SPR EA1N and EA2 PROJECTS

DEADLINE 7 - COMMENTS ON APPLICANTS DEADLINE 6 SUBMISSIONS

Interested Party: SASES **PINS Refs:** 20024106 & 20024110

Flood Risk related Comments on Deadline 6 Submissions in respect of Scottish Power Renewables EA1N and EA2 Project Onshore Works near Friston

Infiltration Basin Structure

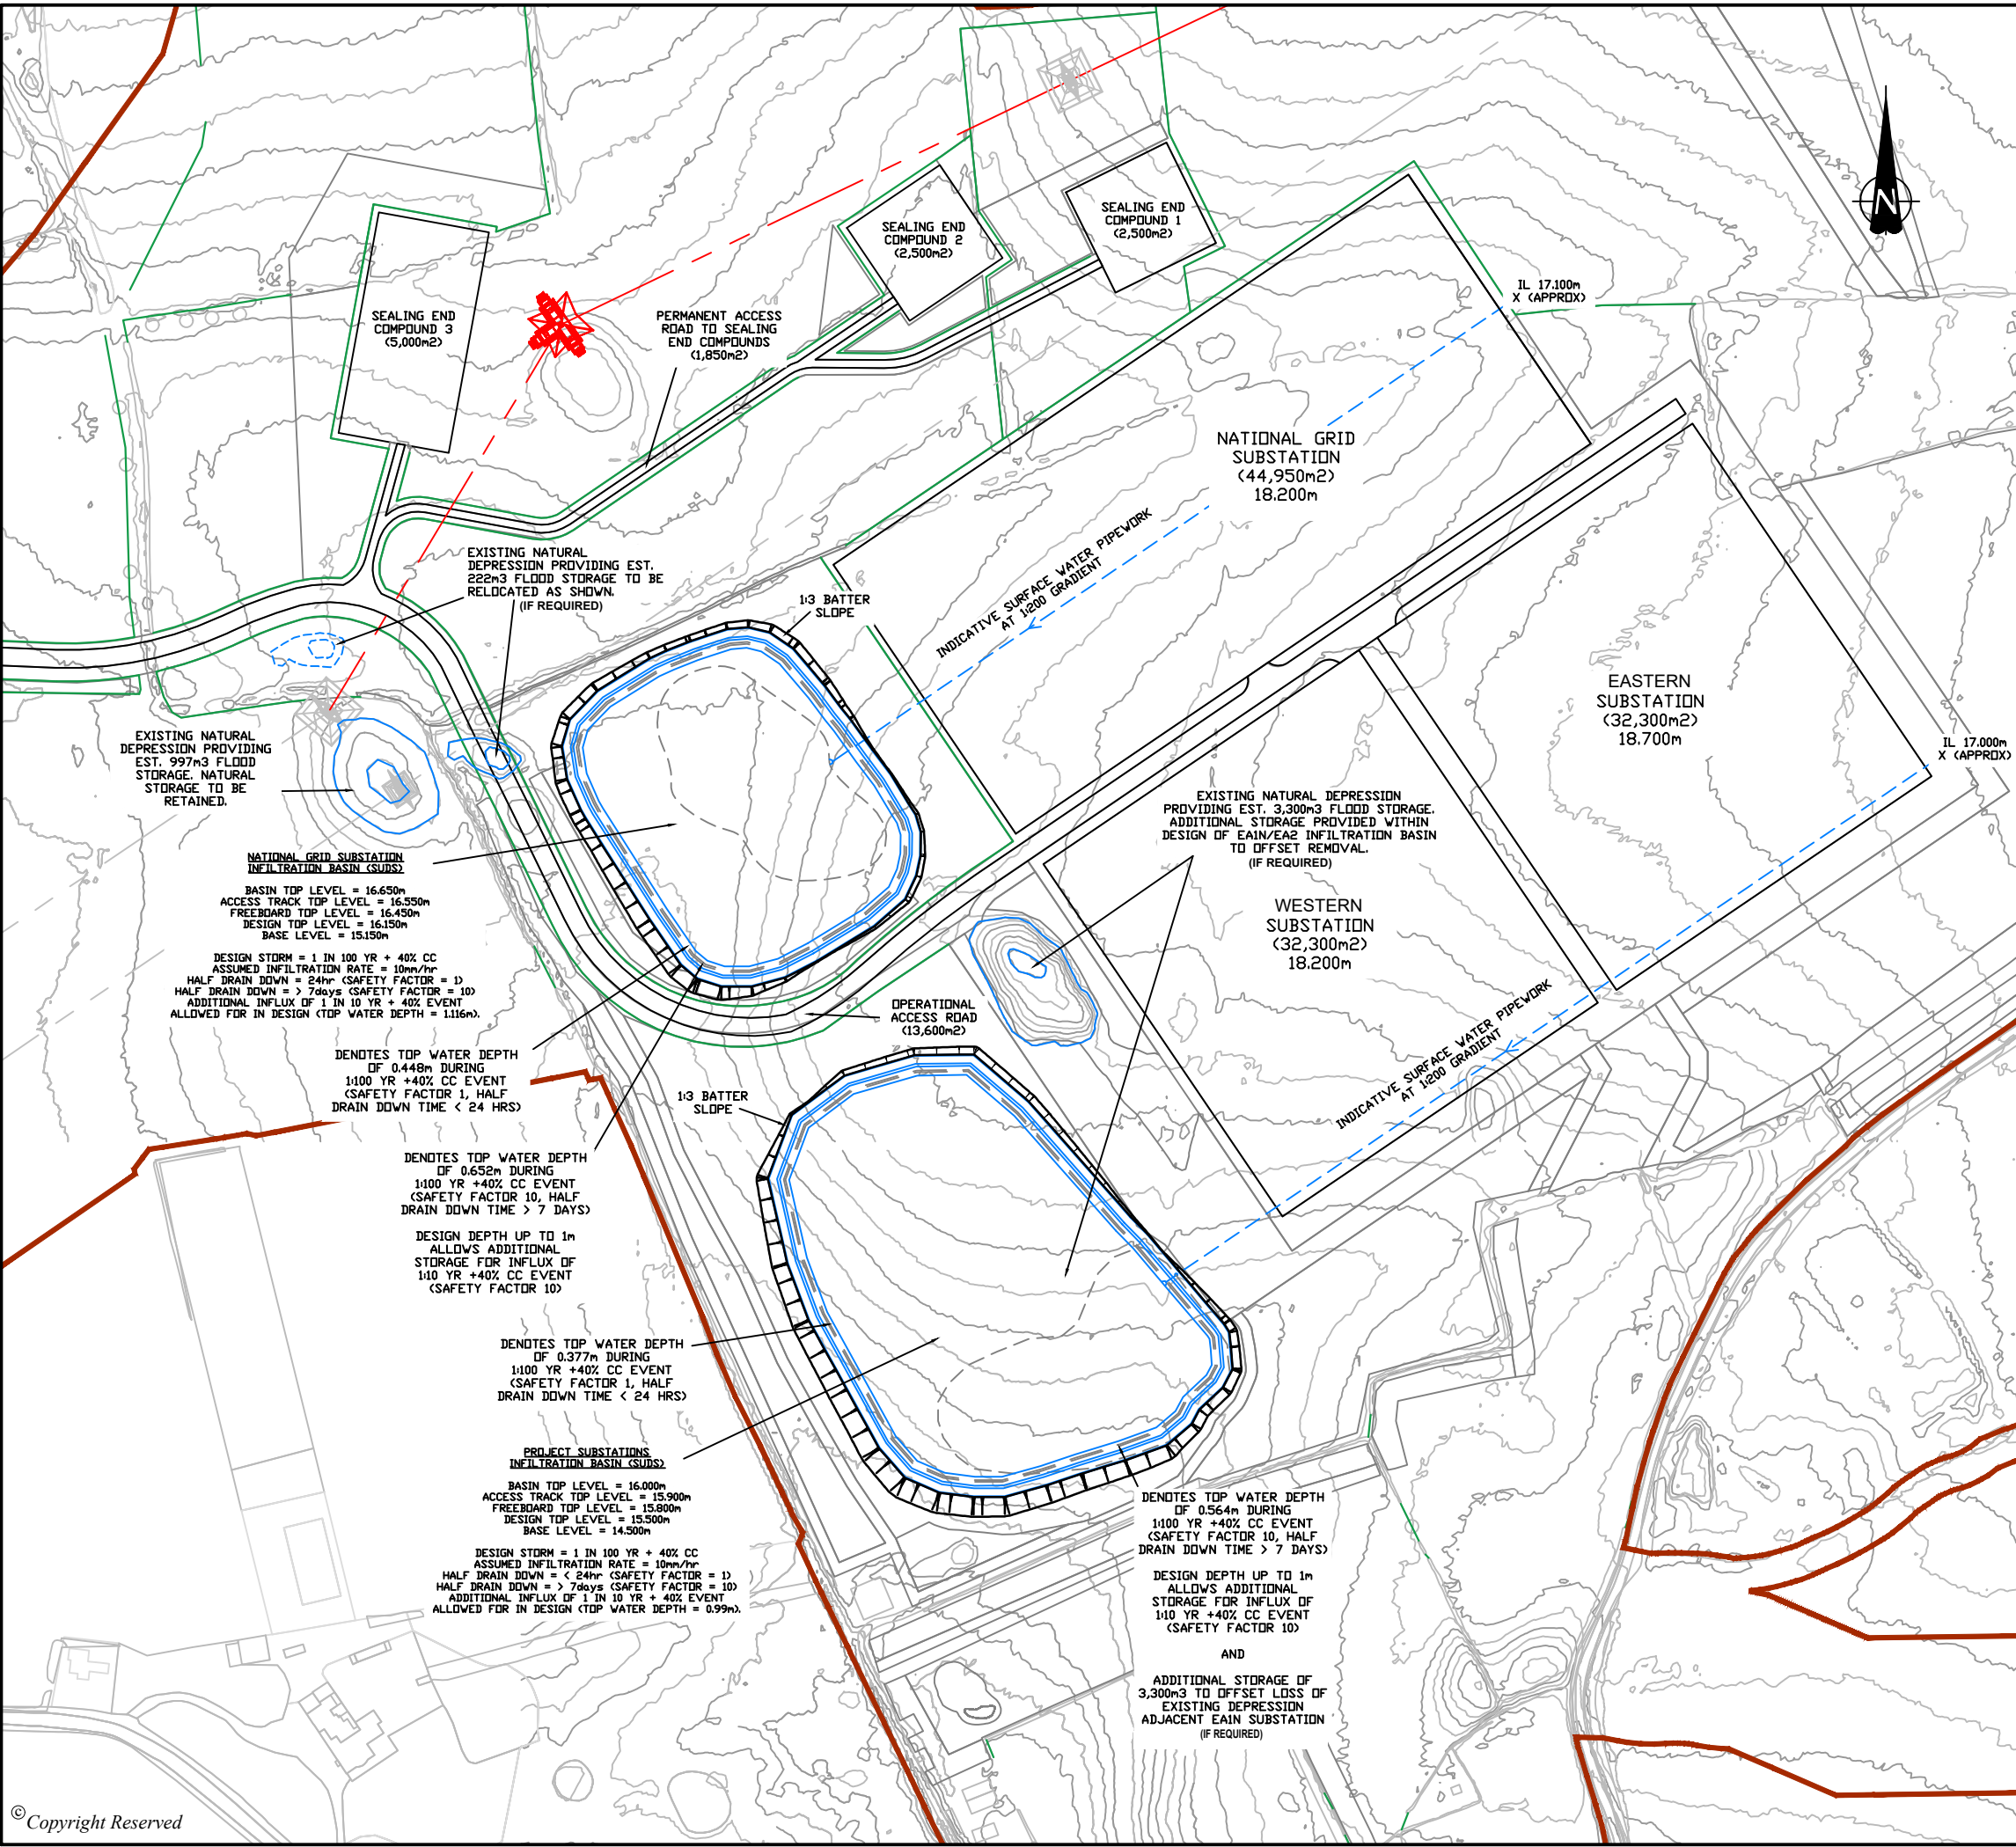
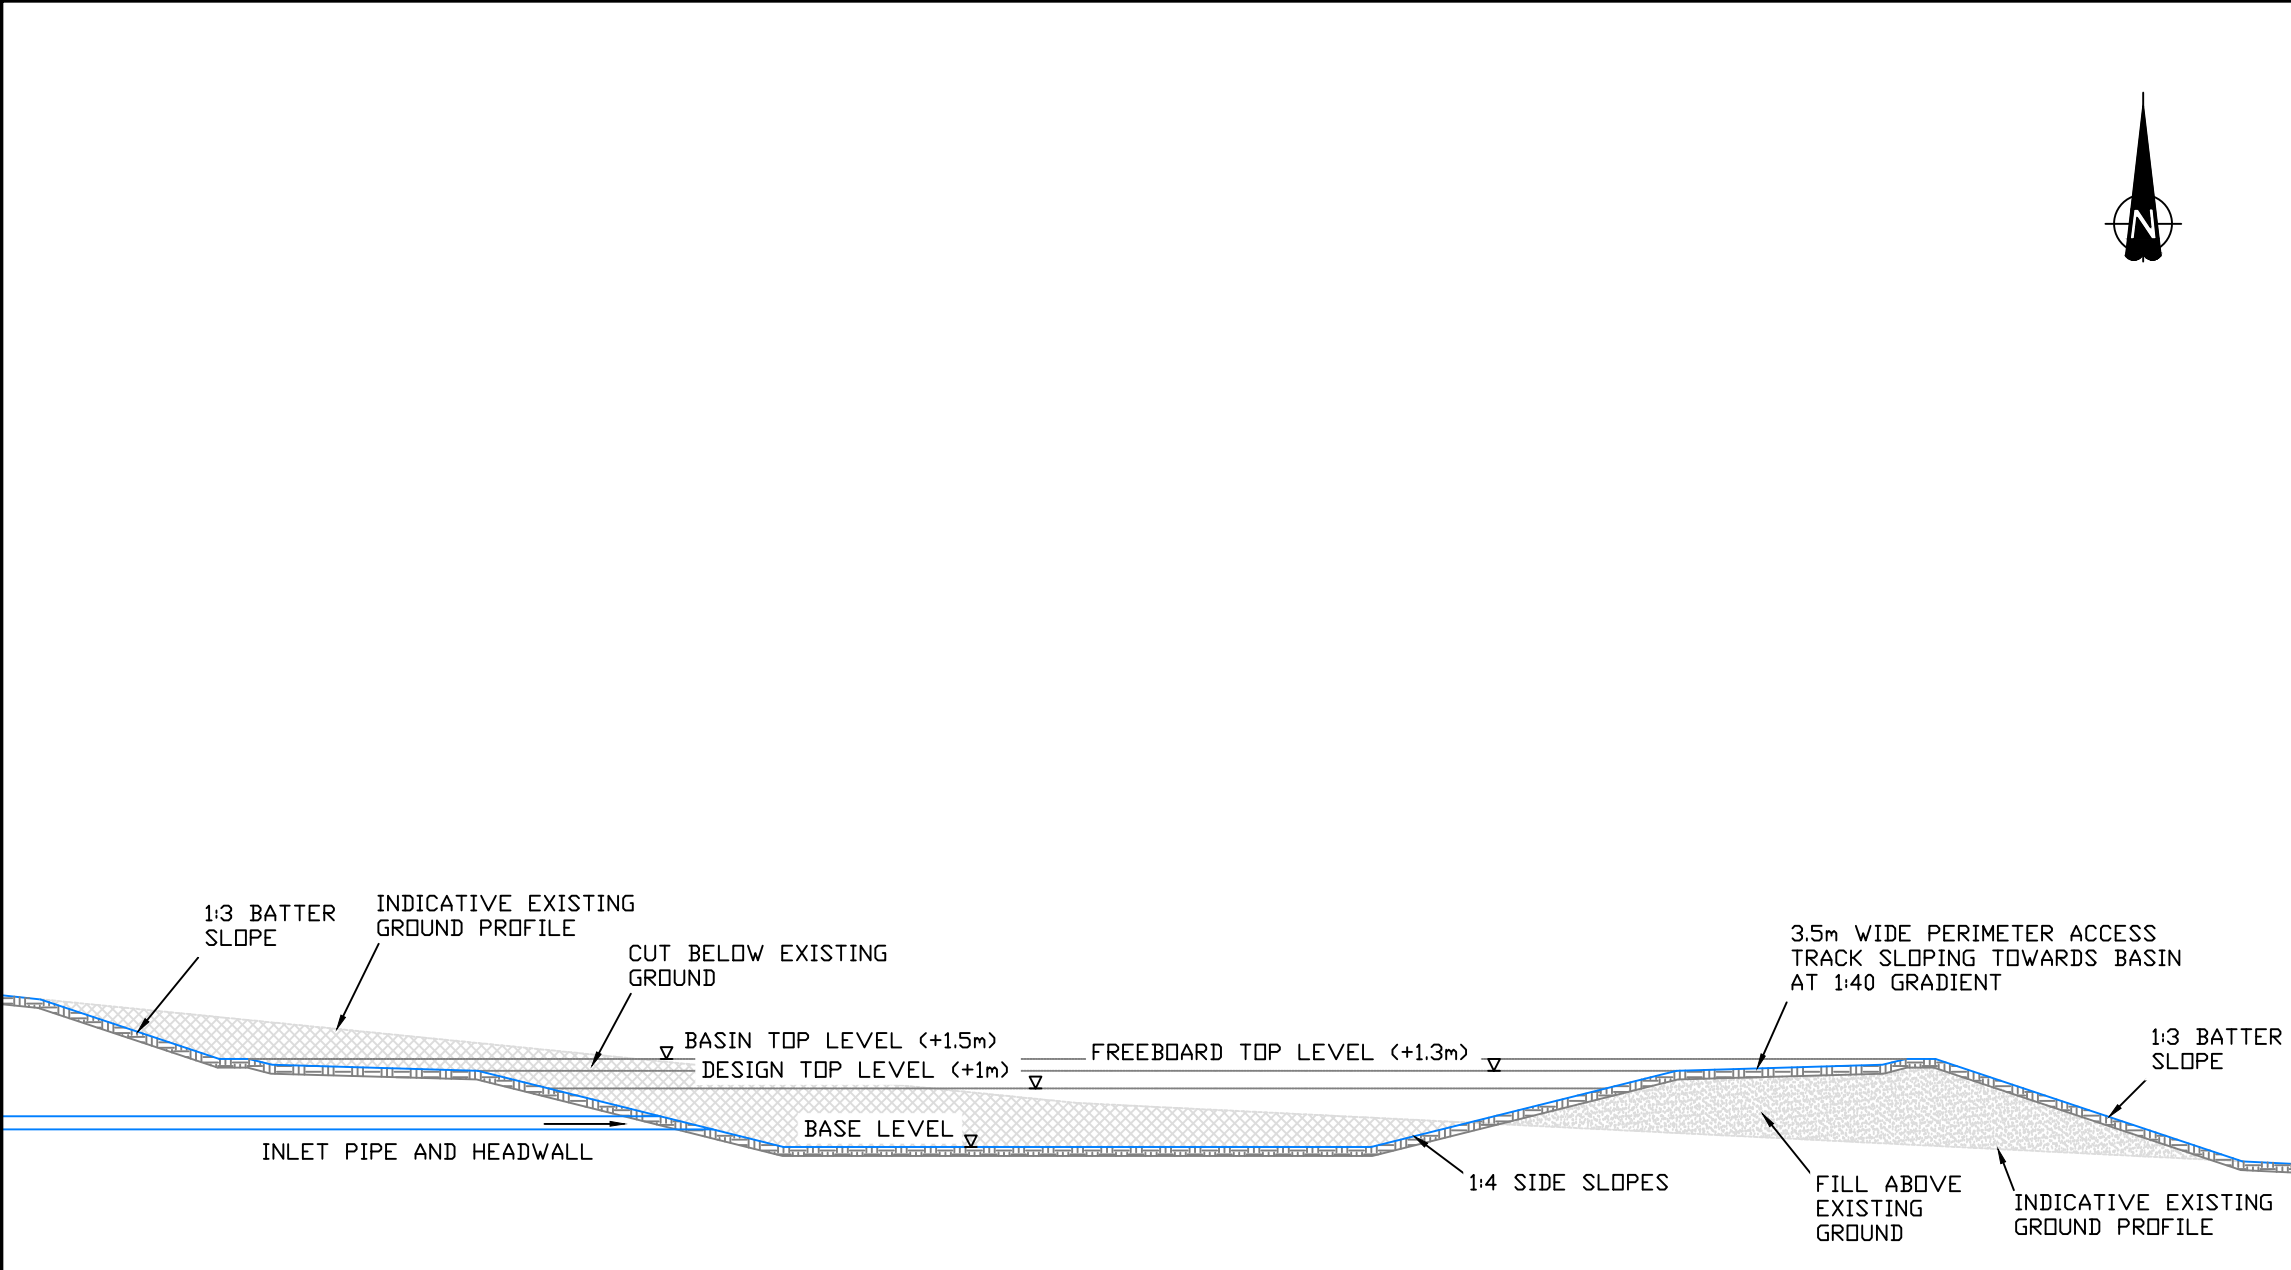
- vii) SPR states the attenuation basins are not above ground level – this is wrong, they are banded on their downslope side;
- viii) SPR hydraulic calculations show the proposed storage volumes are 5-10% more than the design storage volumes – but no sensitivity analysis is provided on the input parameters, the % is too small;

- ix) The total storage volumes presented, including freeboard and landscaping are so large to be captured by the Reservoir Act for the infiltration scheme and are just below the limit

for the attenuation scheme – this highlights the risk presented by these basins when at maximum volume retention, the excessive inundation threat posed to the village, and the concerns over the lack of blockage analysis, lack of consideration of exceedance events and overtopping structures, and lack of engineering construction detail of the retention bunds;

- x) SPR states the wetland nature of the landscaping proposals for the basins – this is inconsistent with the need for extremely well managed attenuation structures to avoid loss of infiltration and minimise blockage risks and over-topping; and
- xi) The SPR plan drawings of the attenuation basins show no outflow from the northern basin area – how does it empty and where does the discharge outfall go to.
